PLANNING BOARD REPORT PORTLAND, MAINE

Seaport Lofts (Bay House Phase II)
101-121 Newbury Street and 40 Hancock Street
Level III Site Plan and Subdivision Review
2013-179
113 Newbury Street, LLC, Applicant

Submitted to: Portland Planning Board	Prepared by: Nell Donaldson, Planner
Public Hearing Date: September 24, 2013	Date: September 20, 2013
Planning Board Report Number: #42-13	CBLs: 20-D-13, 14, 15, 32

AXWB
(one way wall mount)

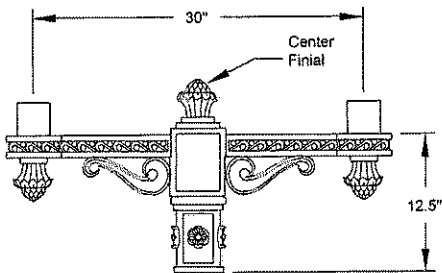
City staff has asked the applicant to reconsider the bracket proposed for the building-mounted lights. Staff has also asked the applicant to reconsider lighting the vestibules at the first floor doorways, which are currently unlit.
